Structural, Plan check reply

Date: 5/ 6 /2021

Project: 4225 89th Ave SE

Permit #: 2012-199

**S** SHEARWALL PERPENDICULAR  
 3/4"=1'-0" TO ROOF TRUSSES

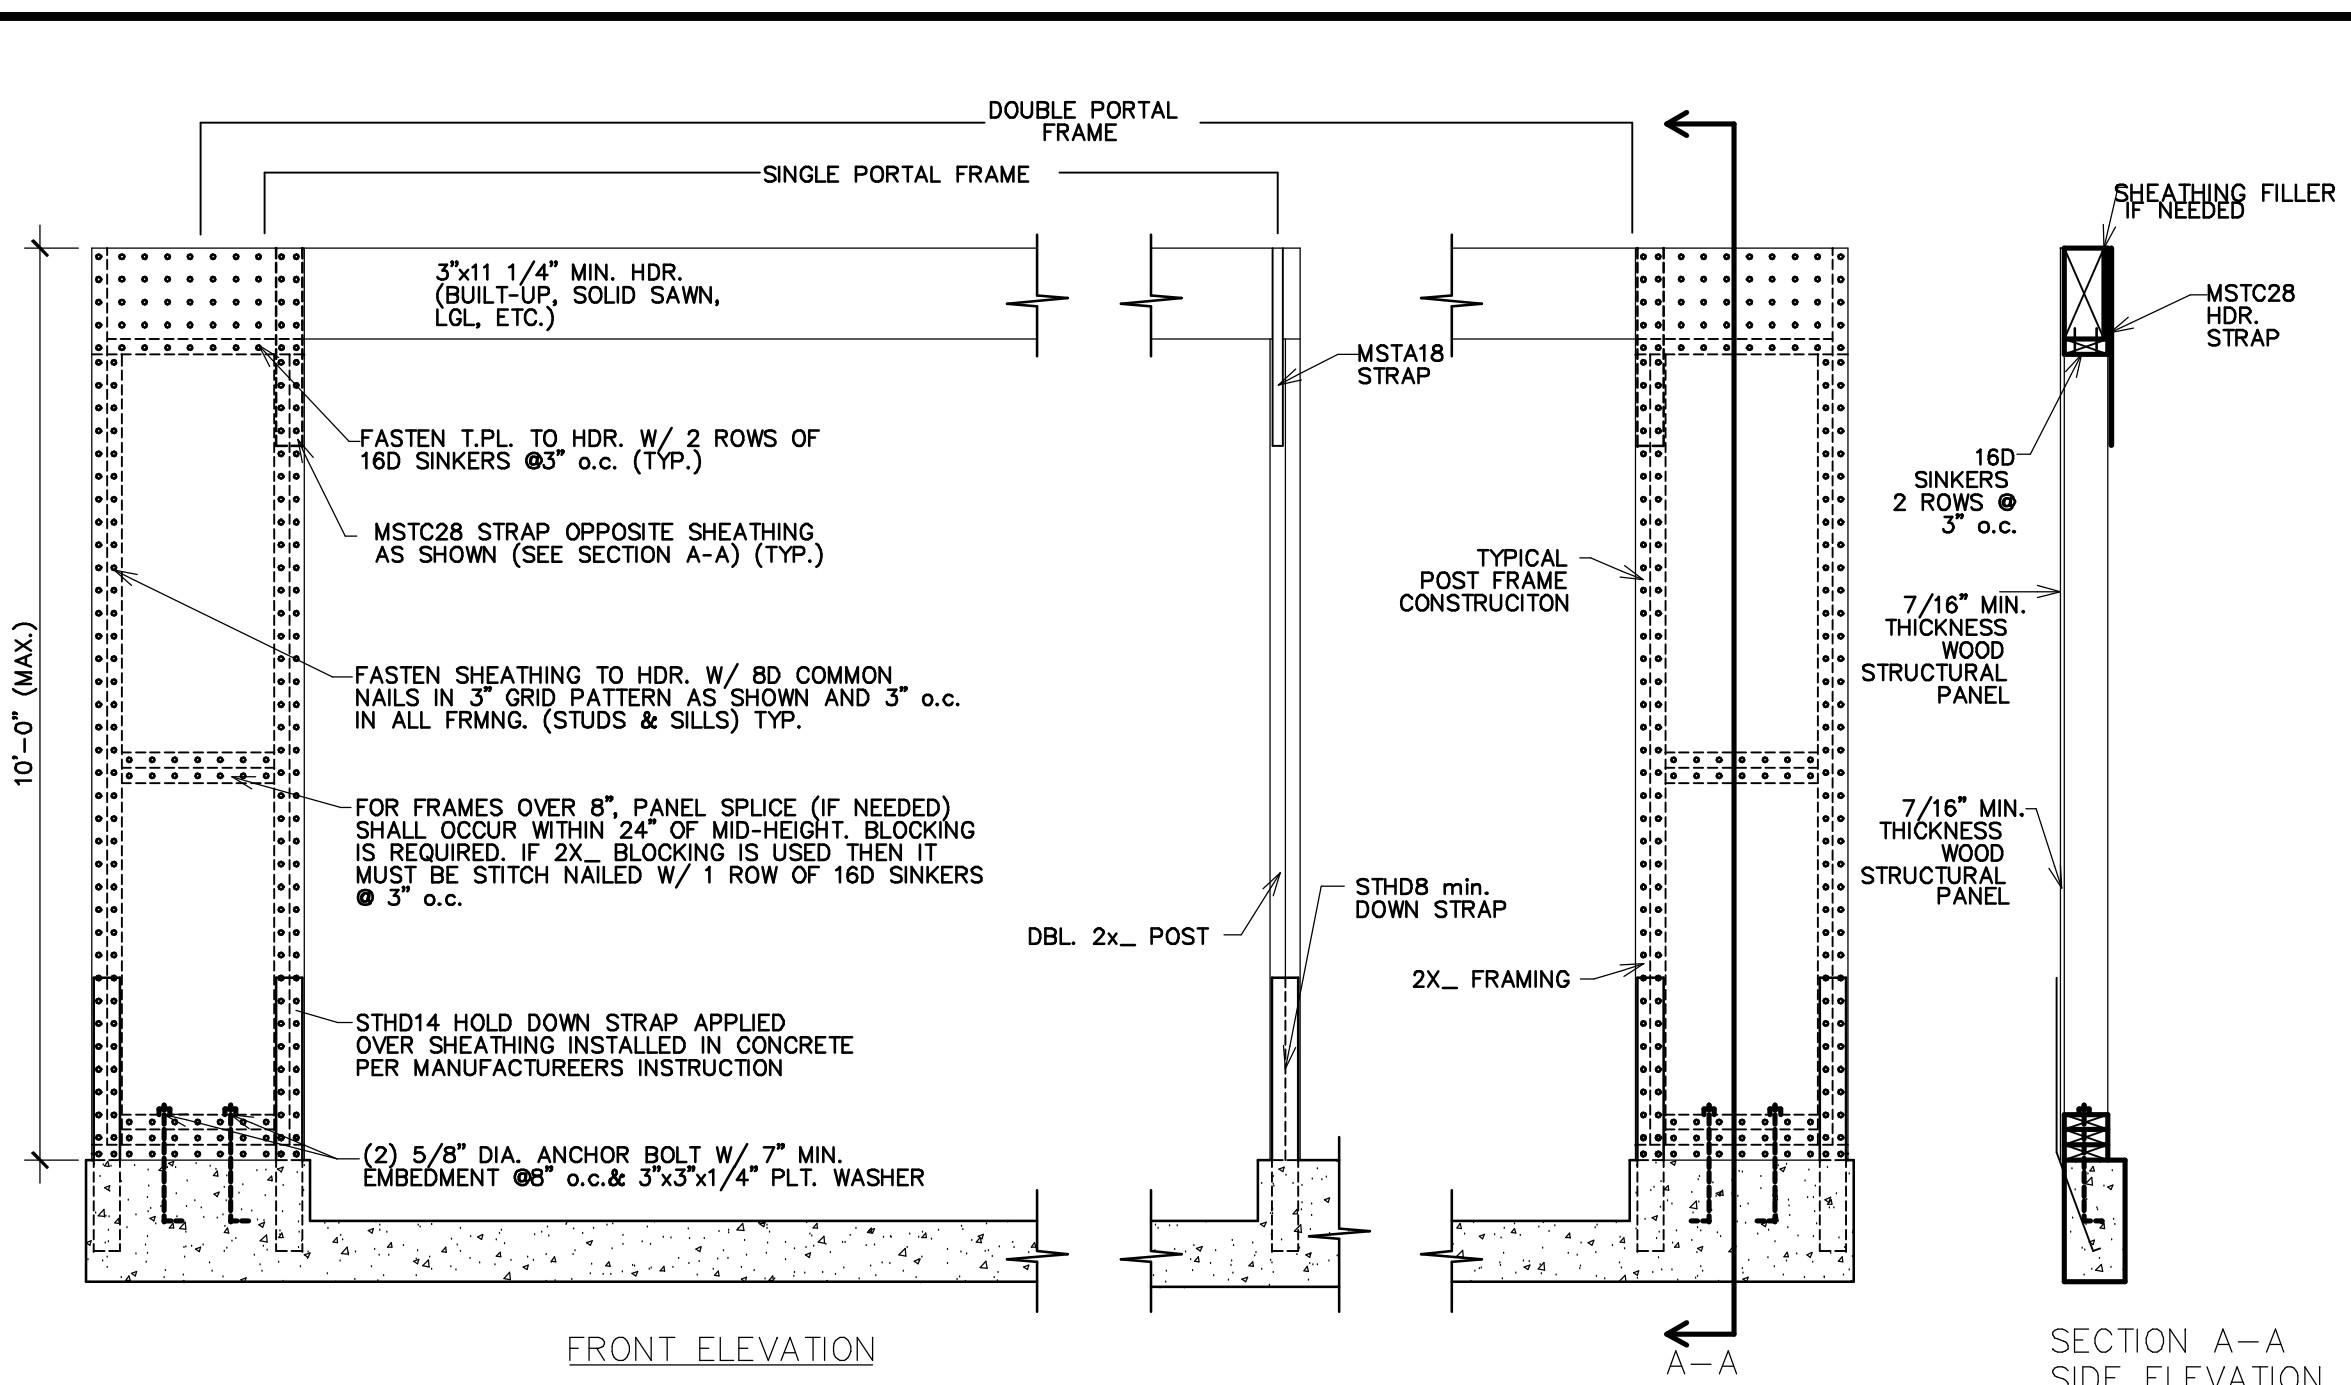
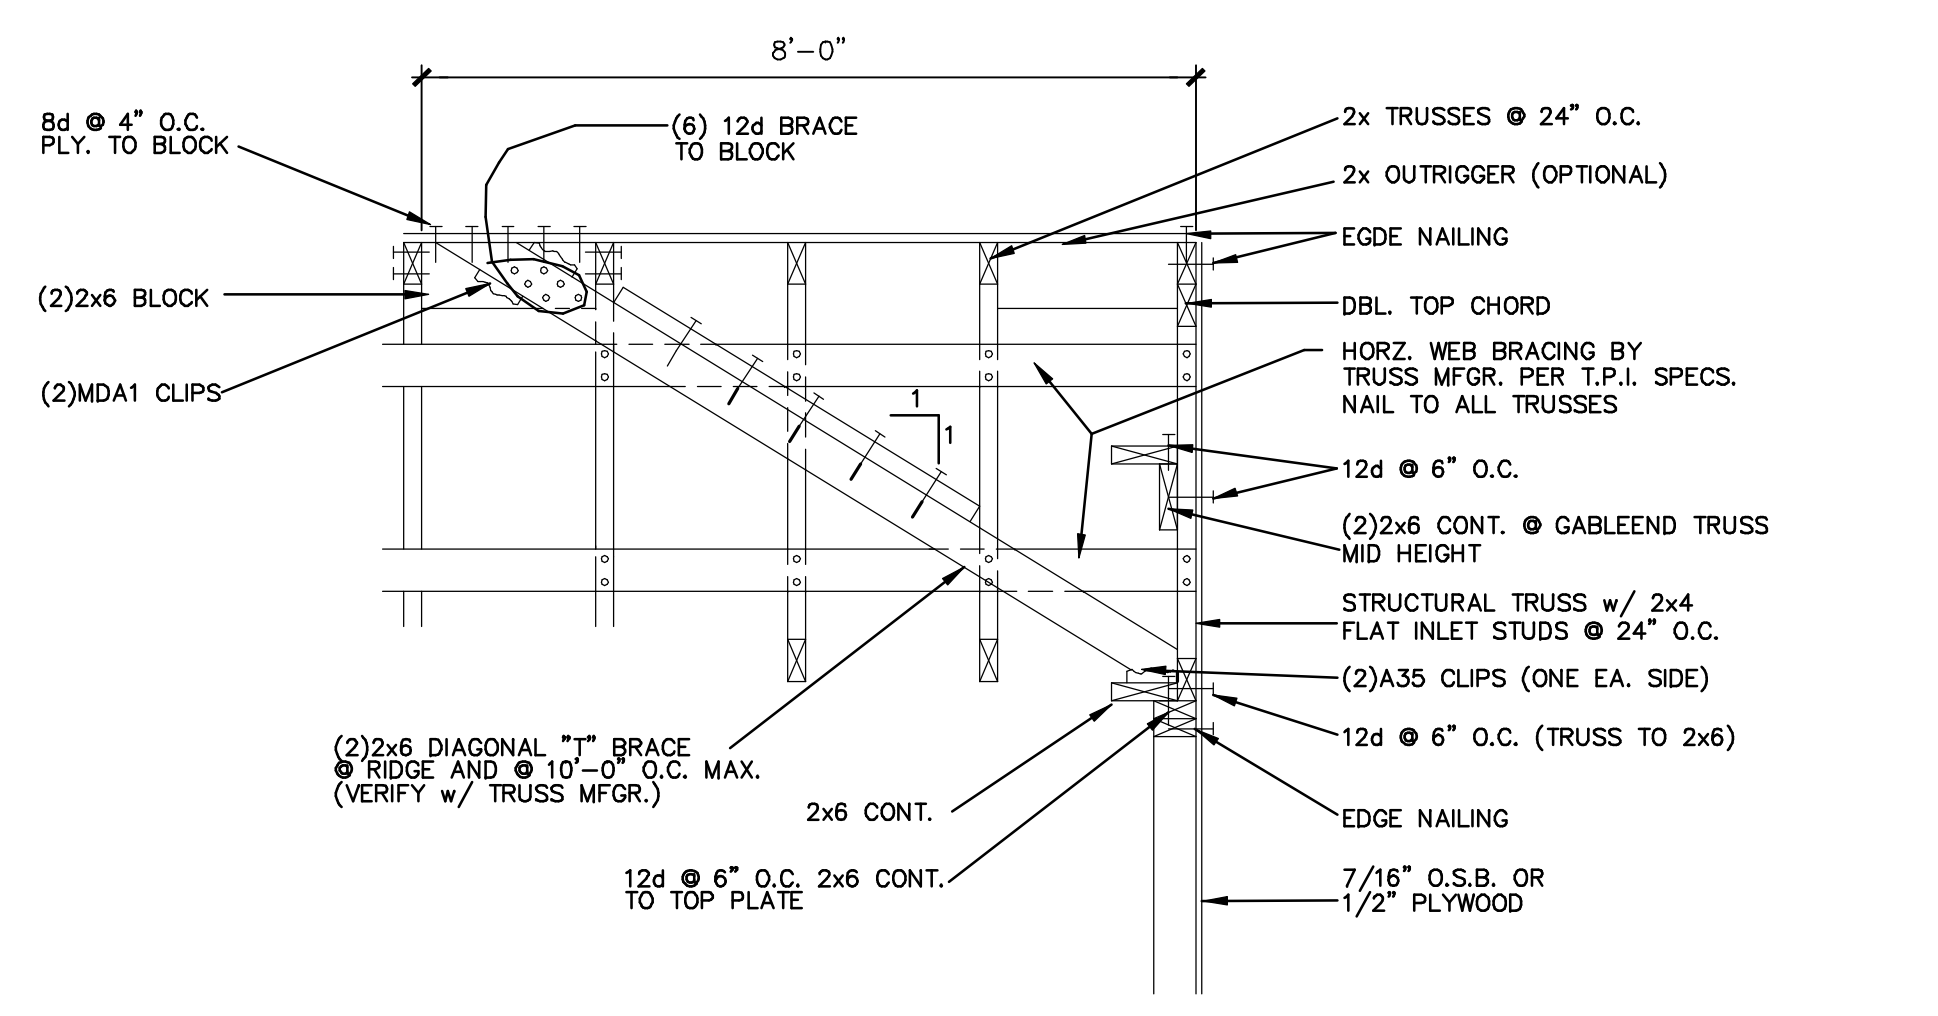
Item #7: Please see revised sheet S2, detail Q/S2 ids deleted.
